**Transport
for NSW**

**Proposed Warehouse and Logistics Hub (SSD 7173), Notice of Exhibition
585 – 649 Mamre Road, Orchard Hills**

TfNSW has reviewed the supporting documentation and comments relating to traffic generation assumptions, travel demand, heavy vehicles and construction traffic management. These are outlined at **TAB A** for consideration.

FIRST ESTATE MASTERPLAN

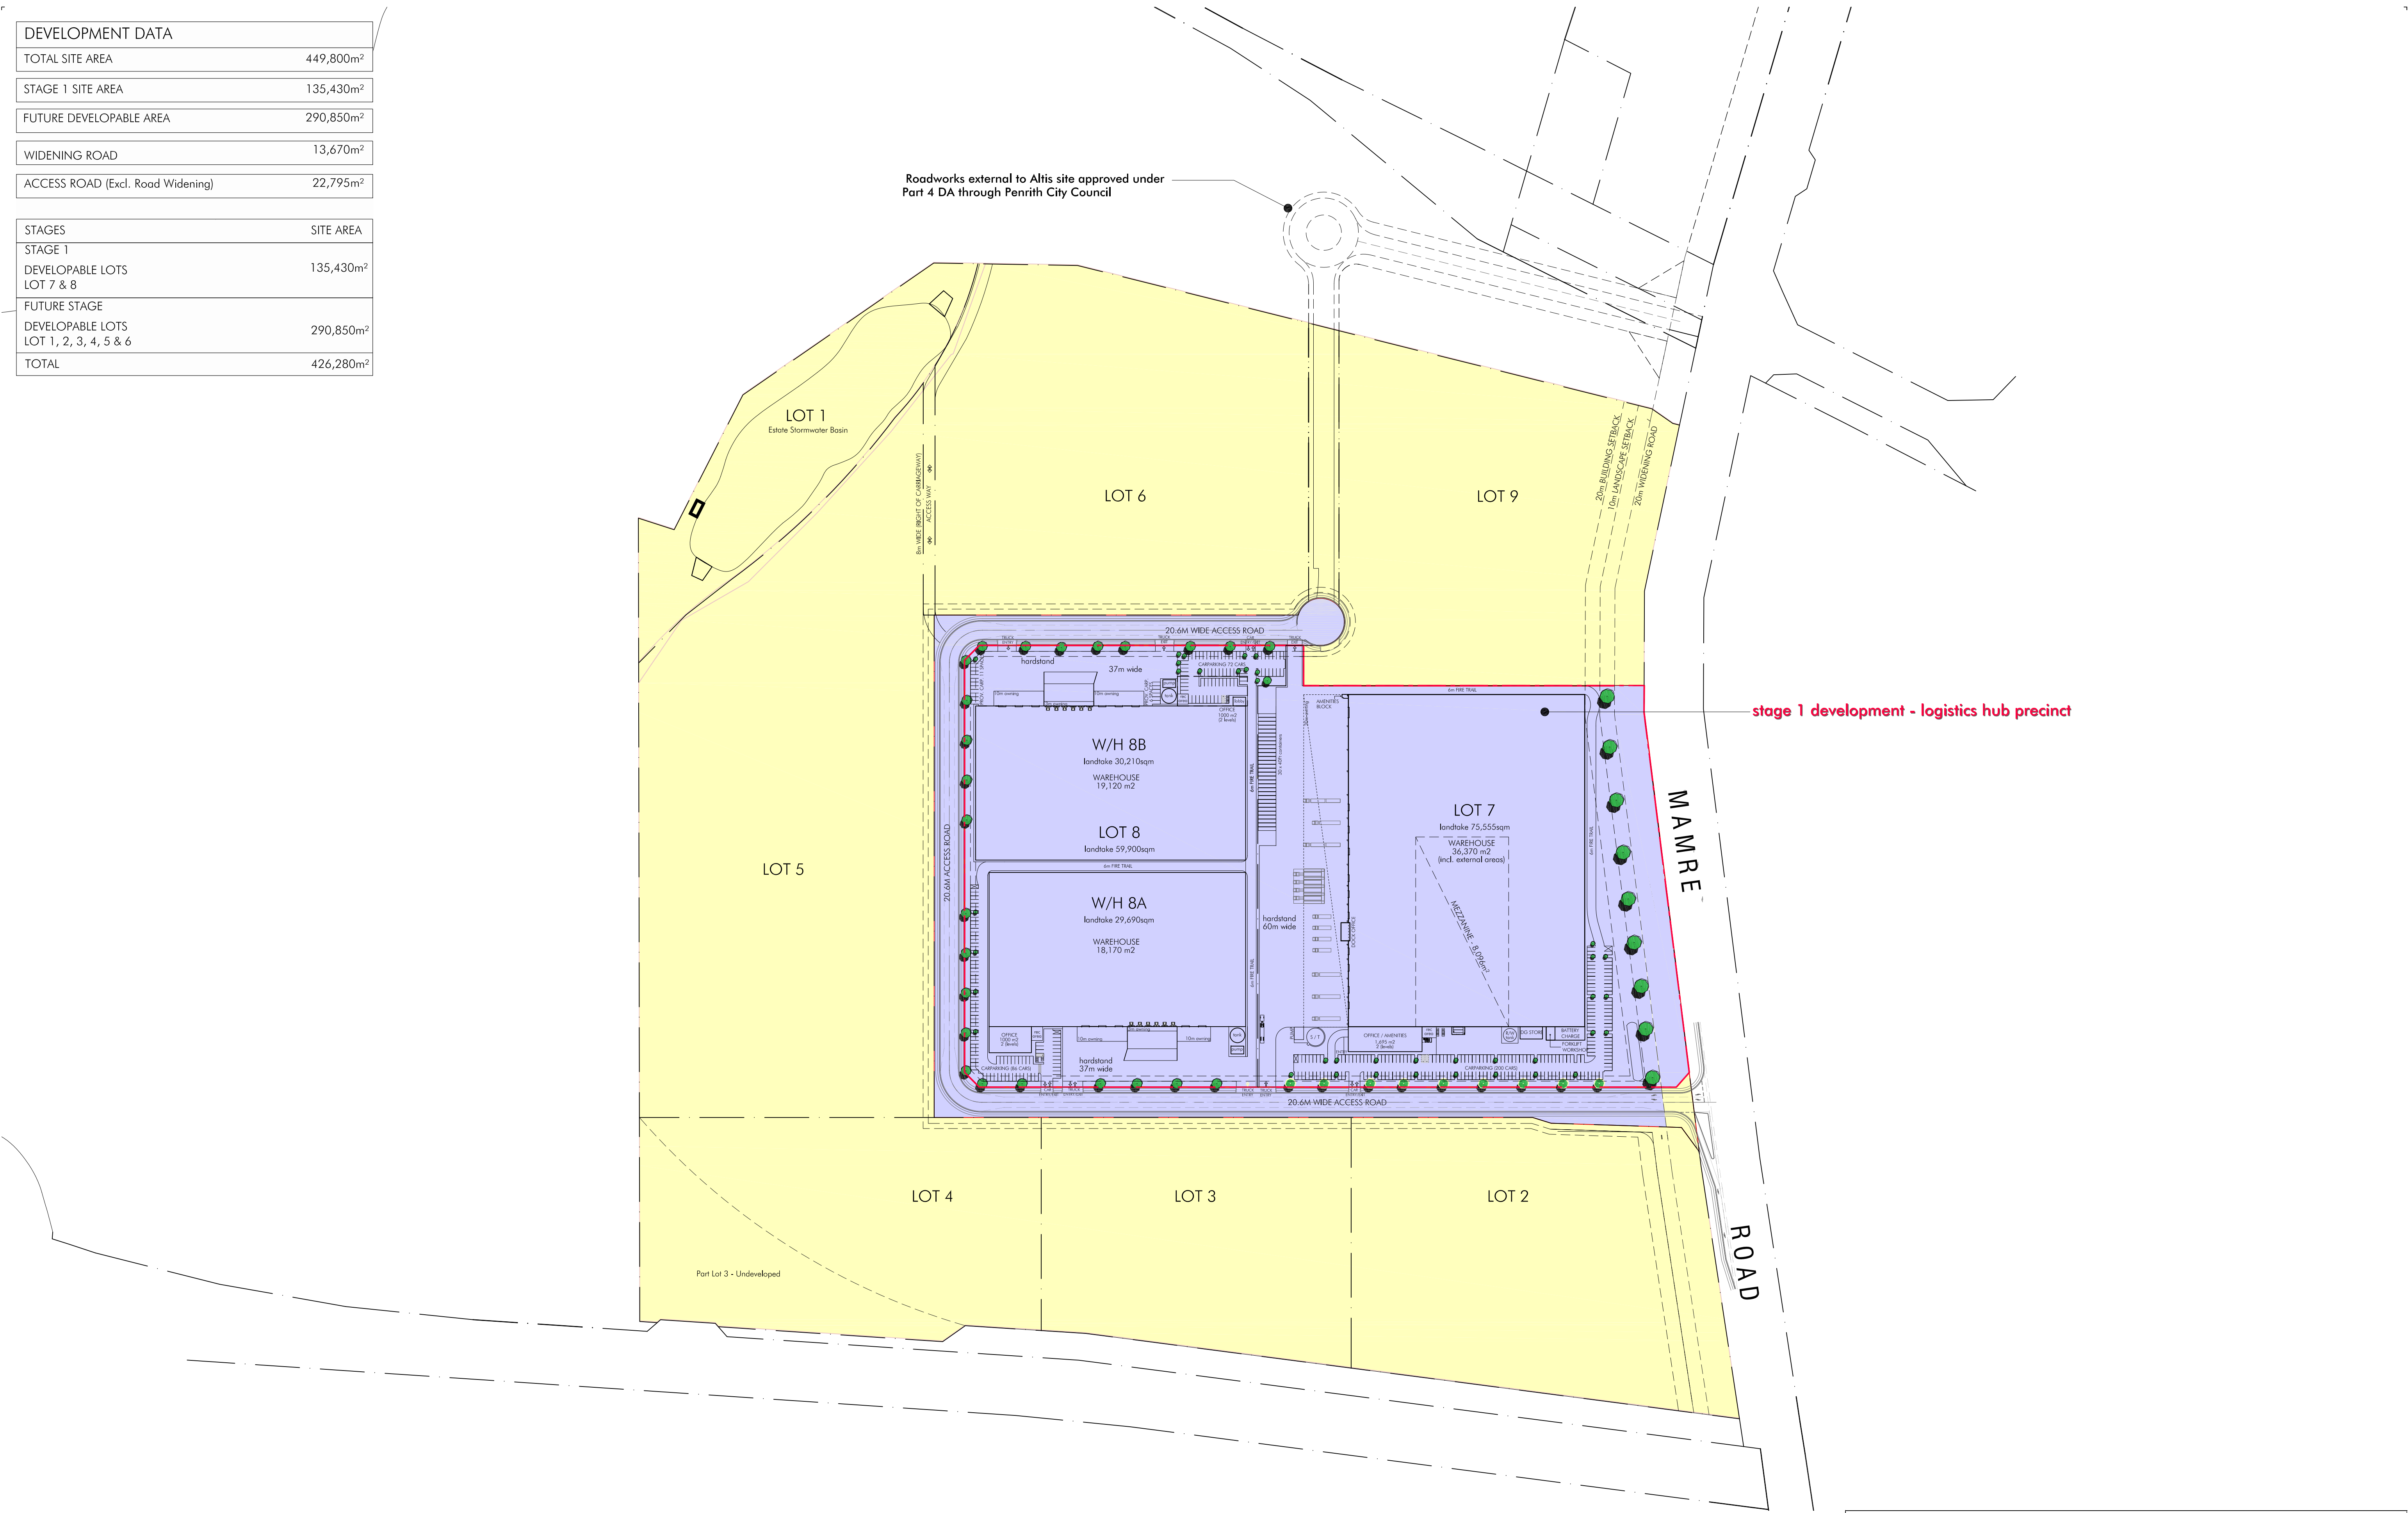
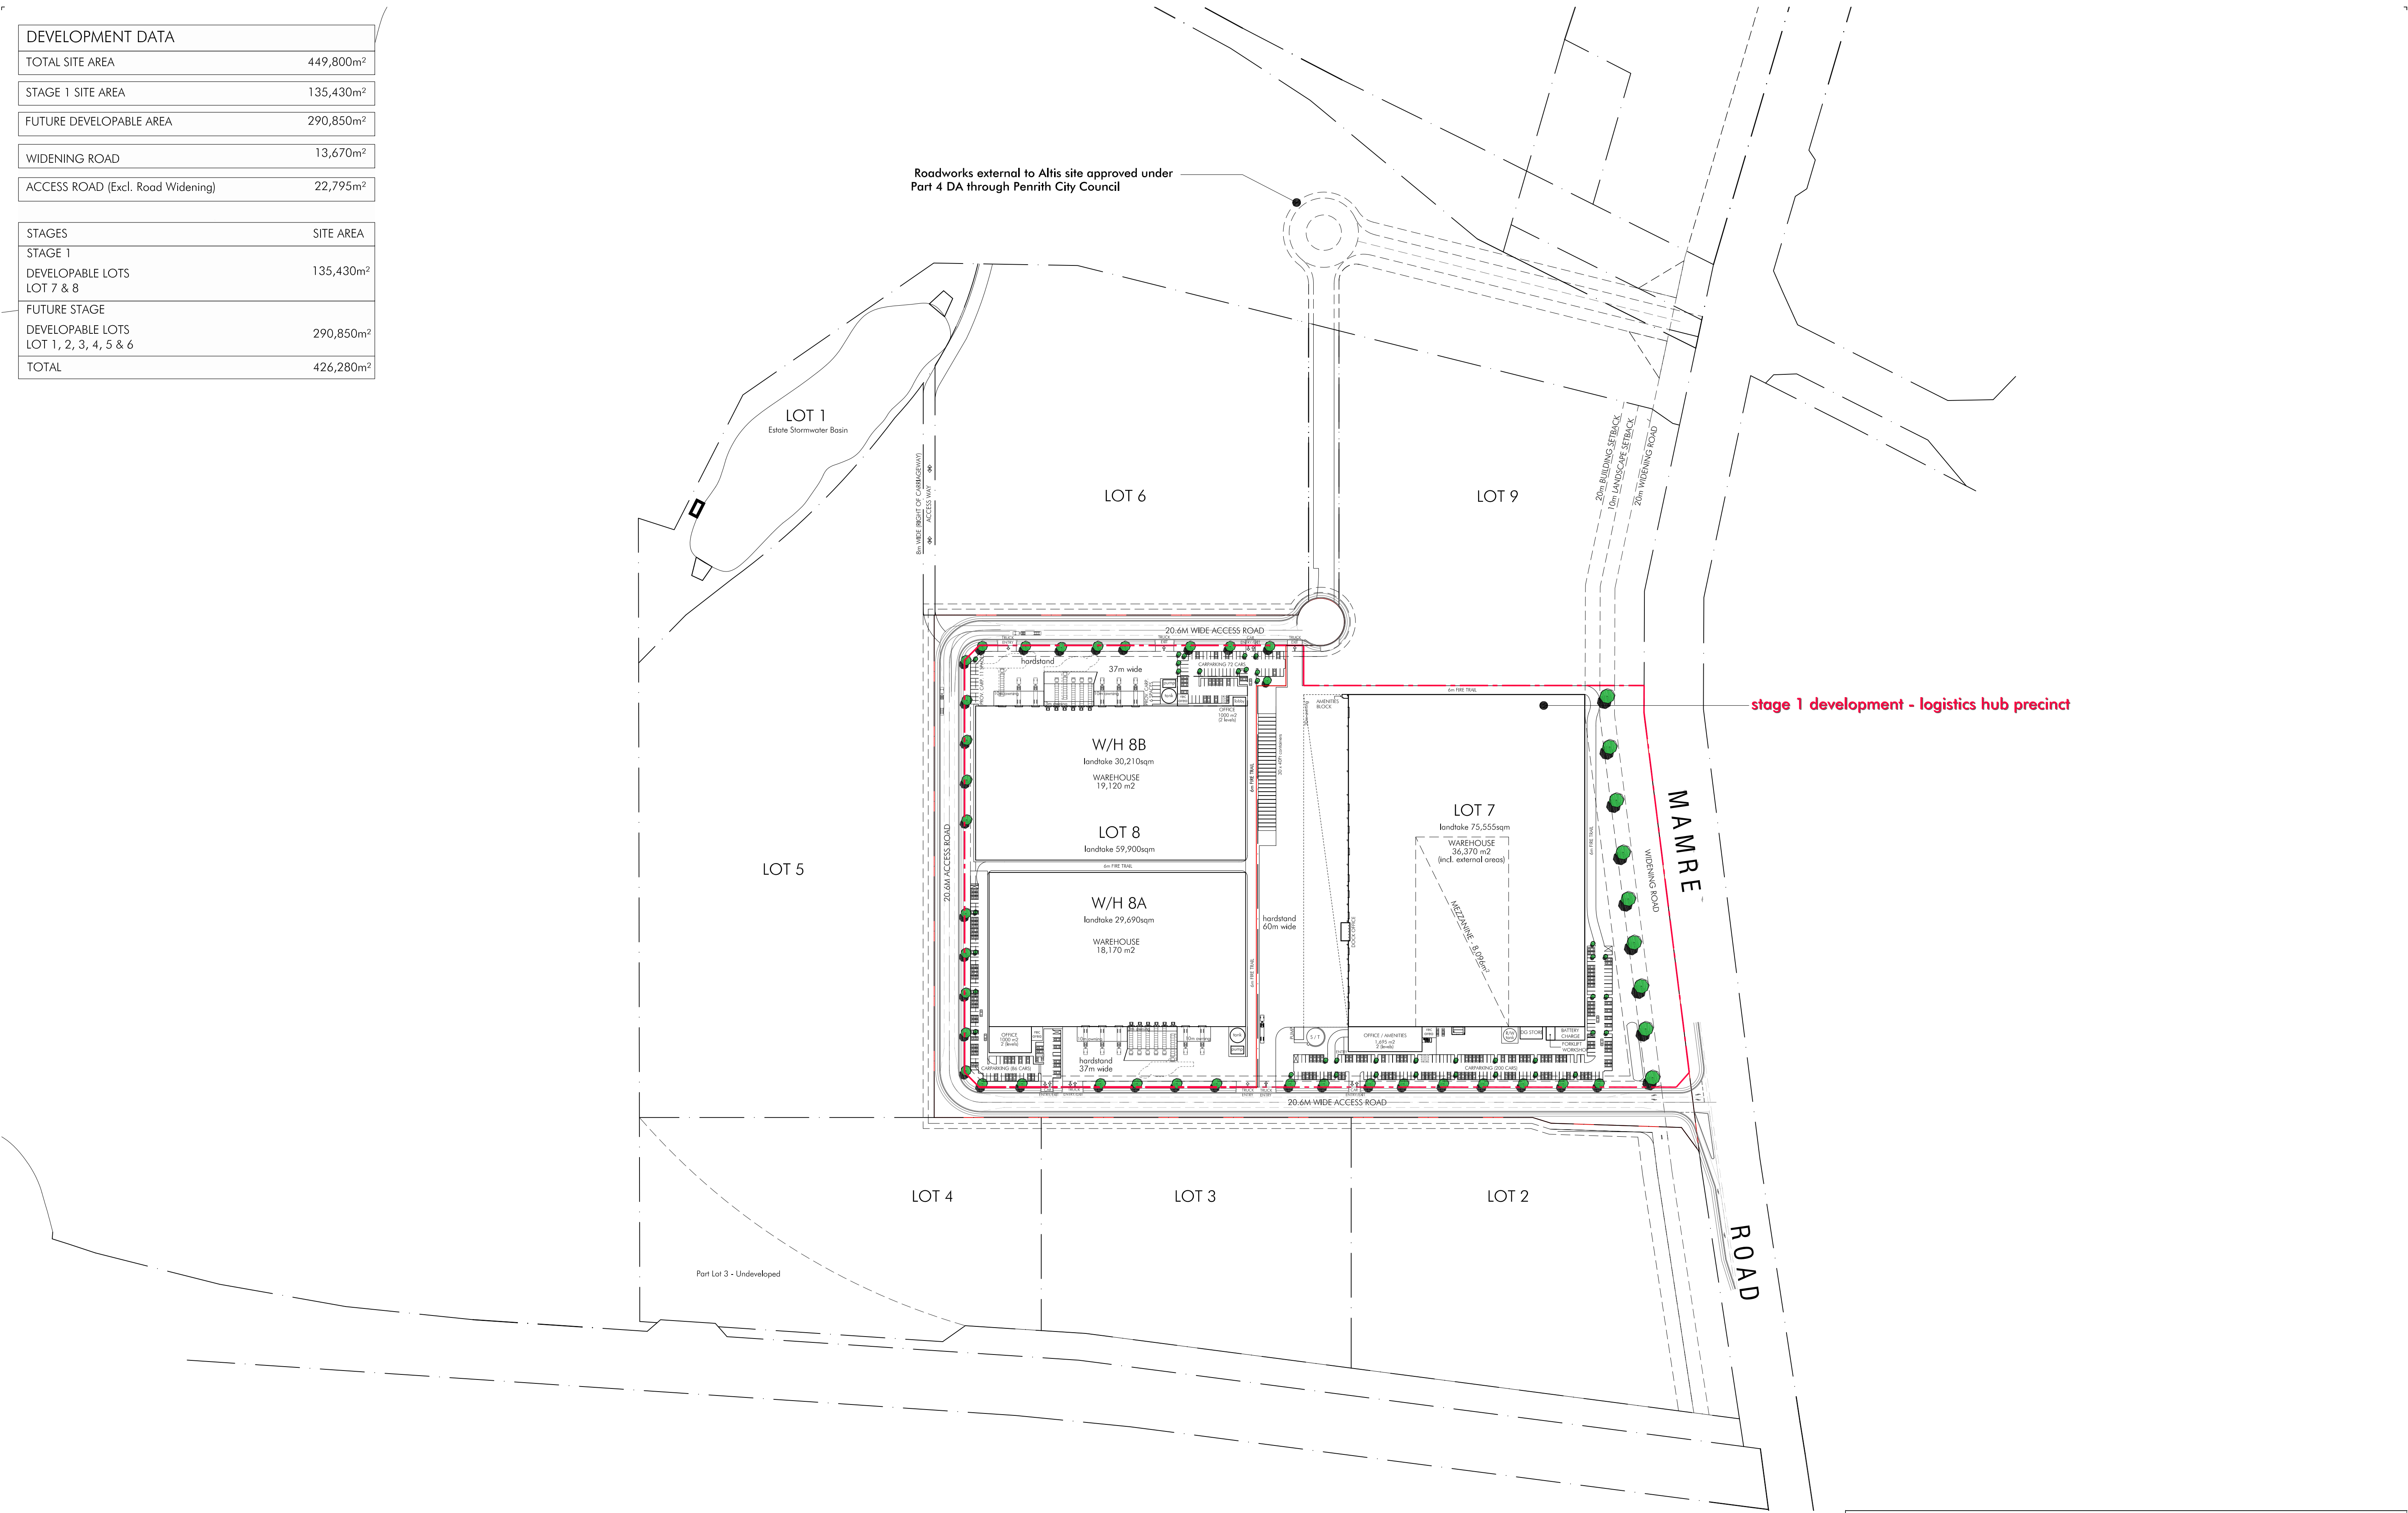
It is suggested that designated truck parking areas or truck coupling/decoupling areas be considered to allow safe and efficient manoeuvring of vehicles on the site. The design plans should be updated accordingly.
